Rezoning Transportation Analysis

Petition Number: Insert Zoning Petition #2021-260

Date	Description
04-18-2022	First Review (WB)

DATE: 11/03/2021  
DESIGNED BY: CMG  
DRAWN BY: JYK  
CHECKED BY: JYK  
SCALE: 1/8" = 1'-0"  
PROJECT #: 1021386  
SHEET #: **RZ-1**

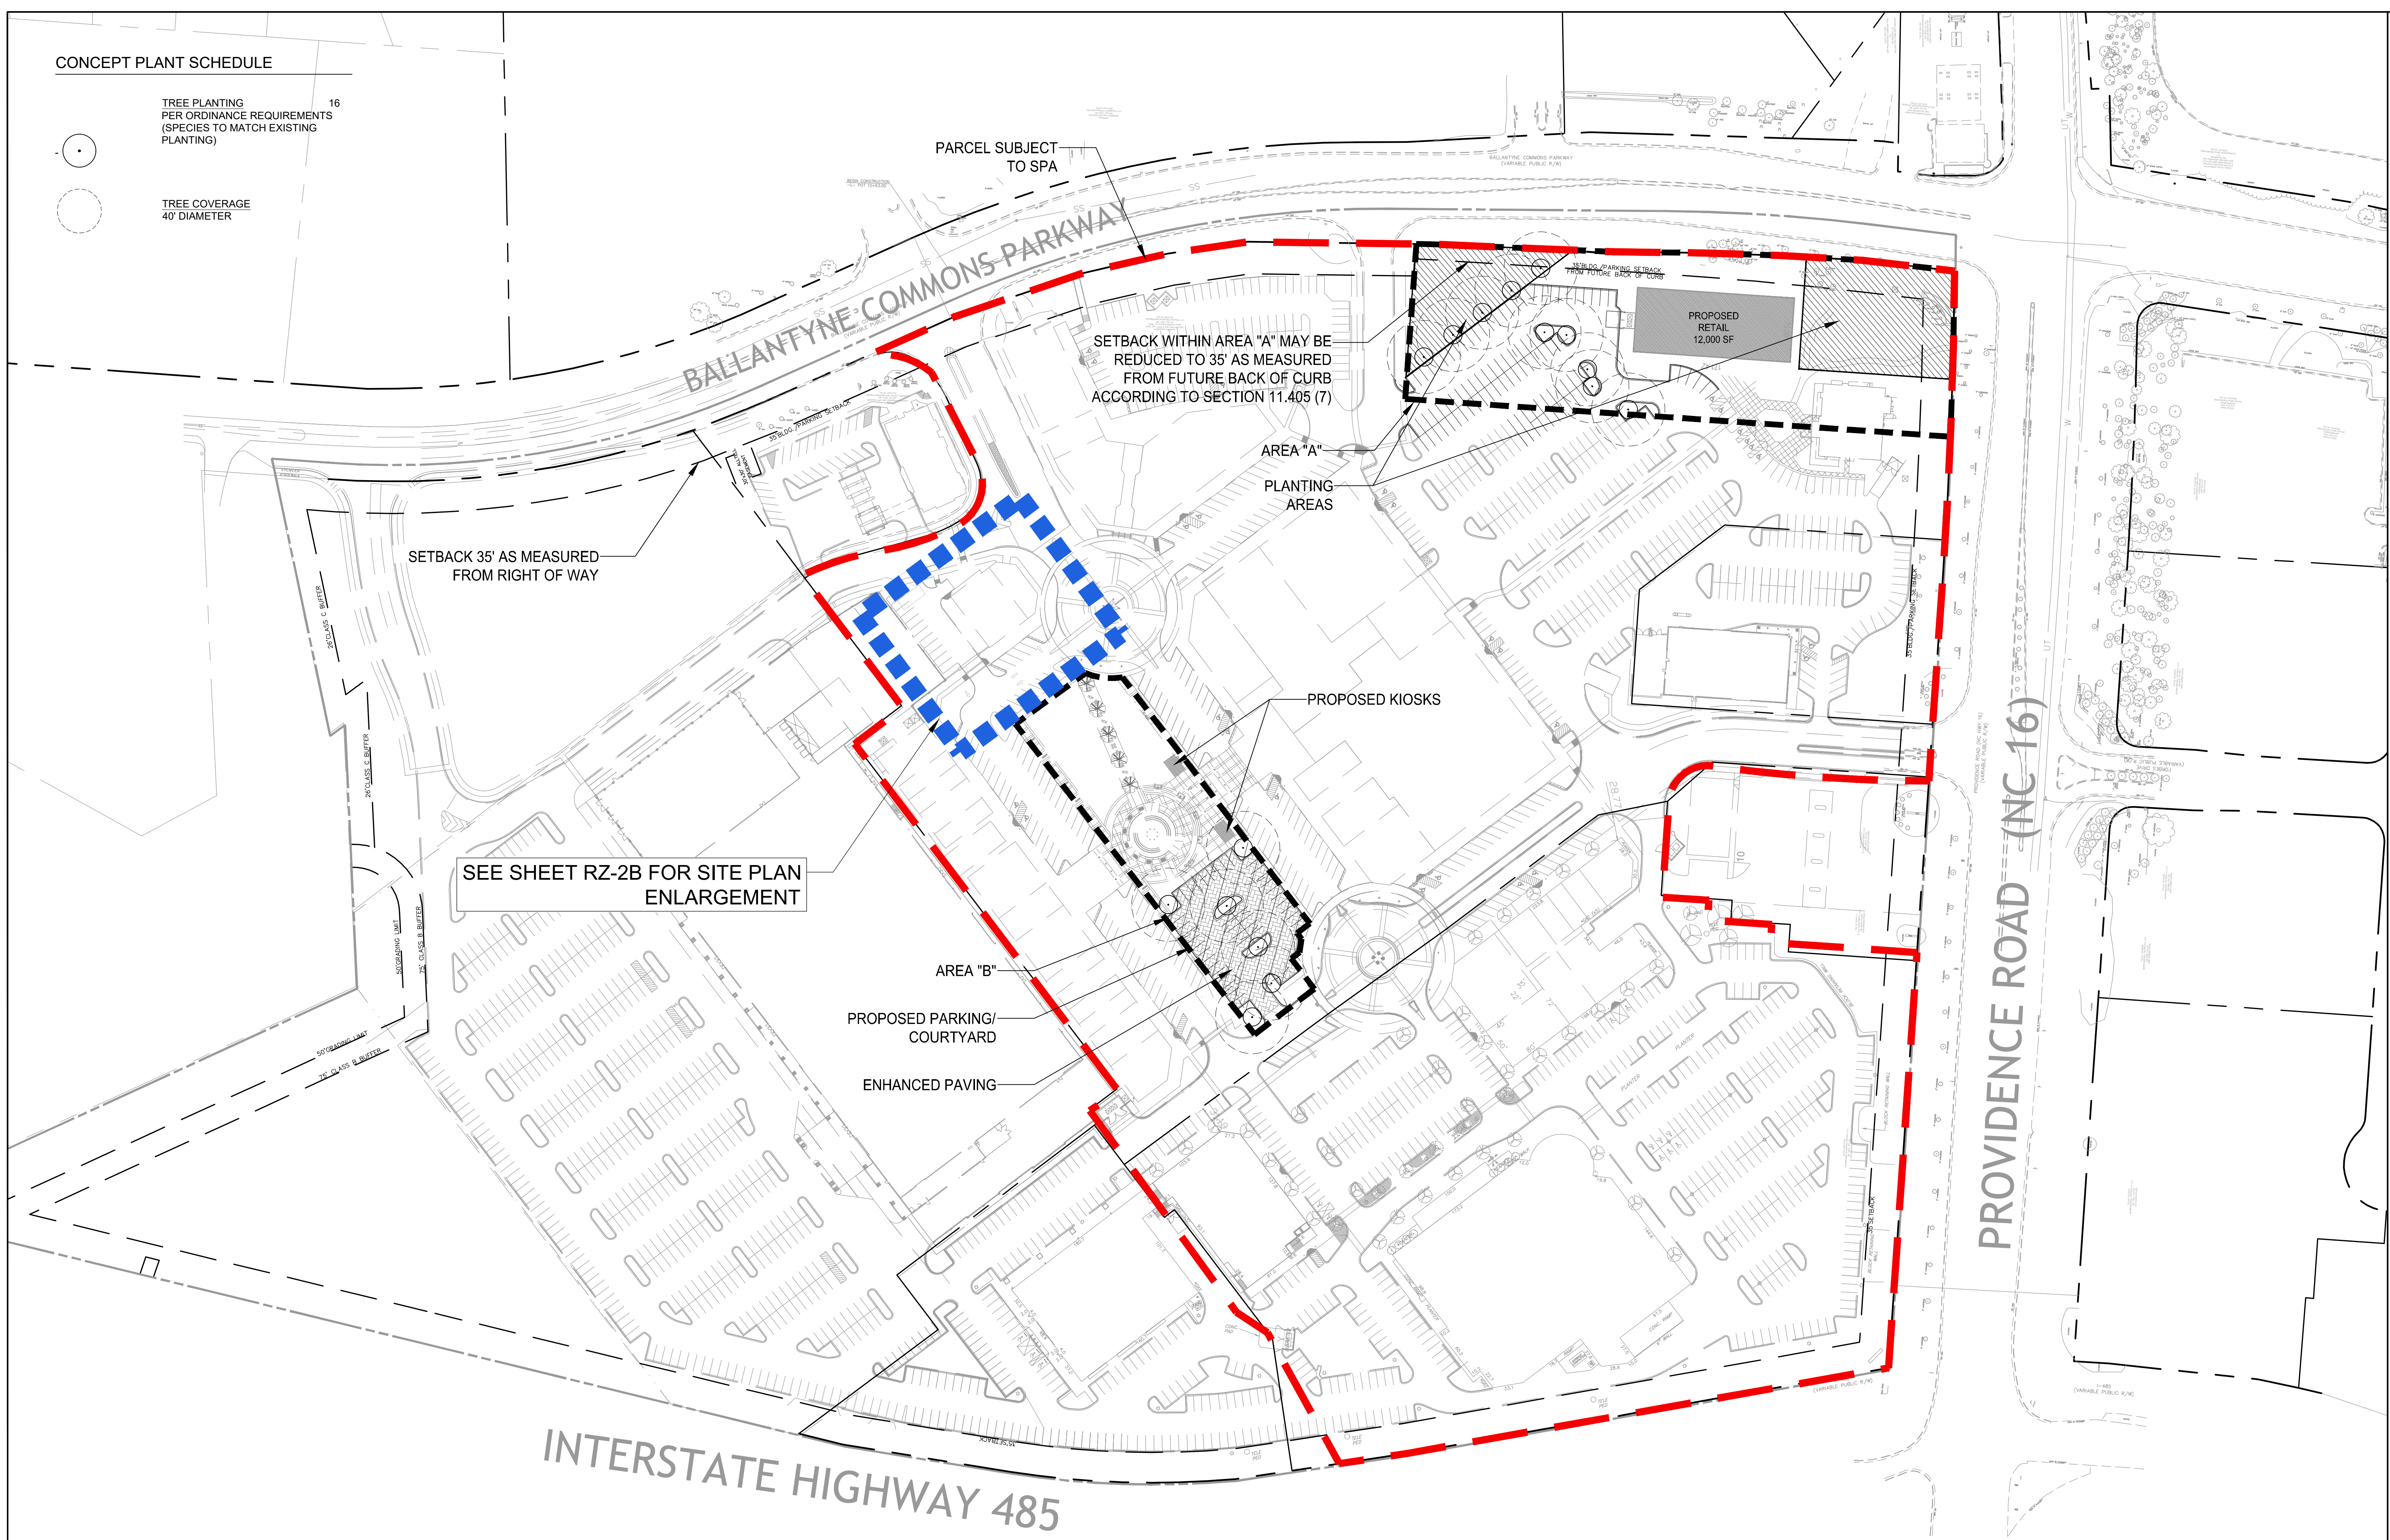
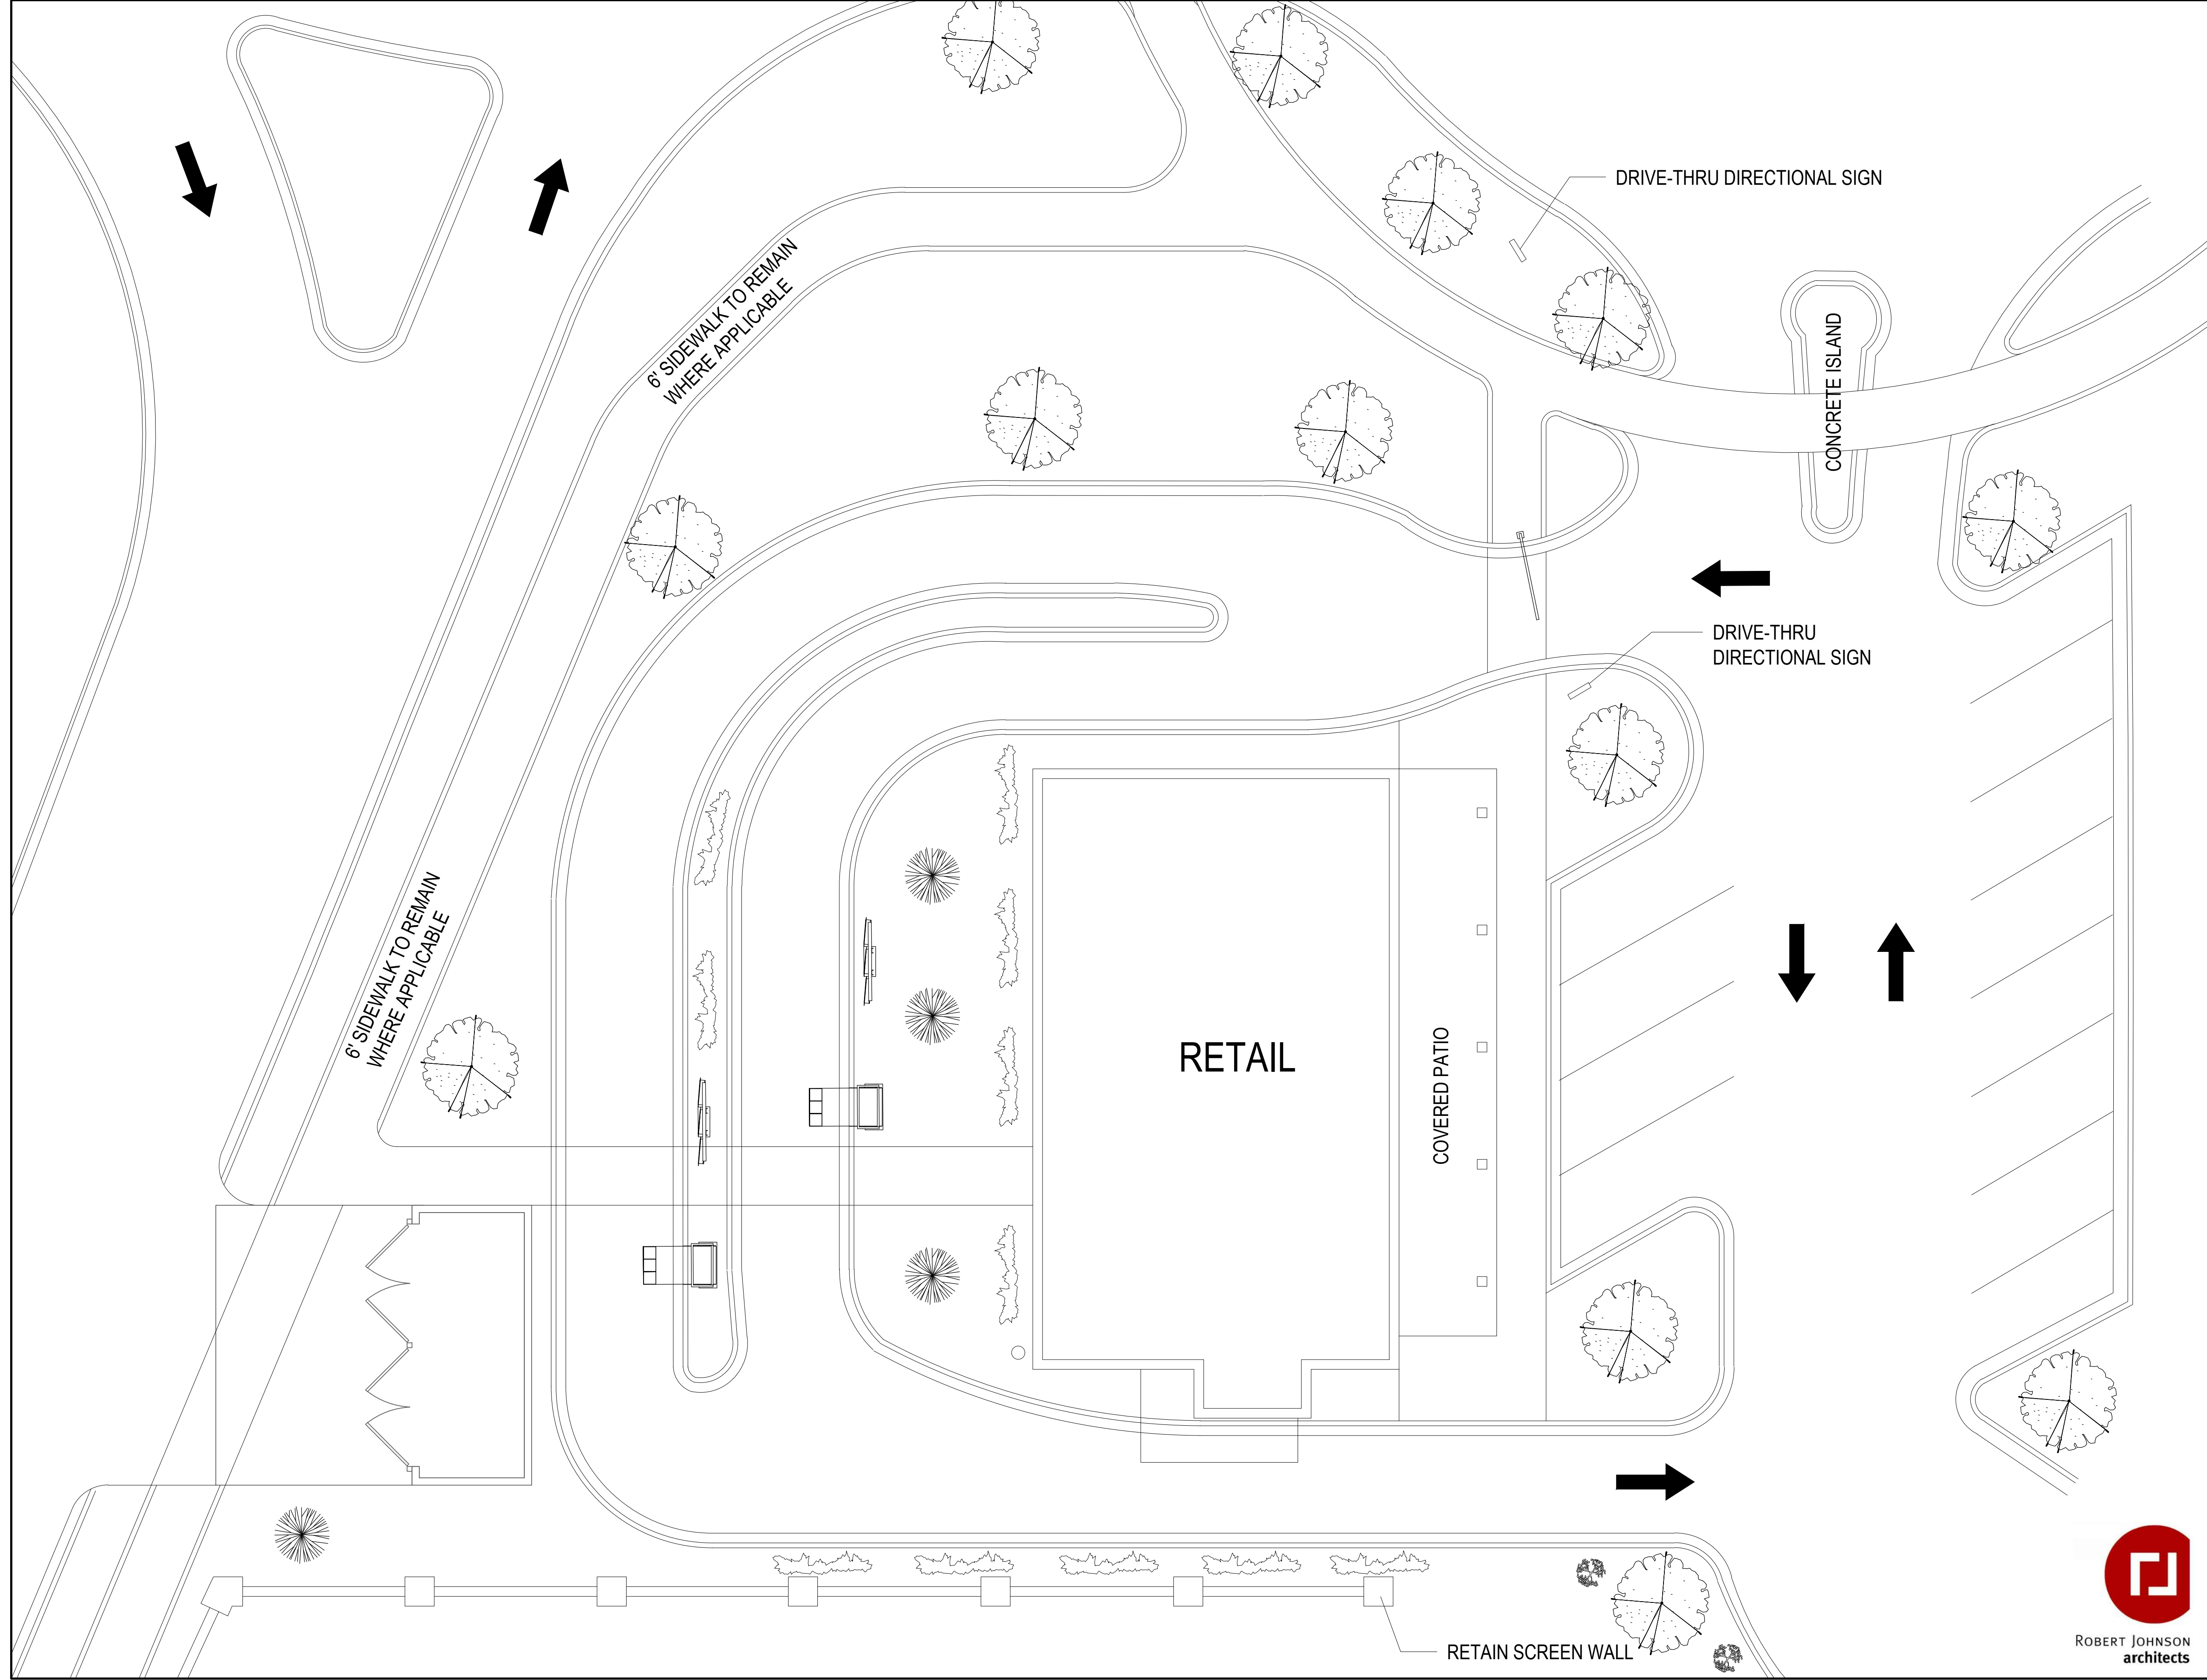
Label and dimension the curb and gutter from the centerline for each road on the site plan.

3. Revise site plan and conditional notes to provide on-site stacking without queueing within the roundabout or the Promenade Drive stem toward Ballantyne Commons Parkway.
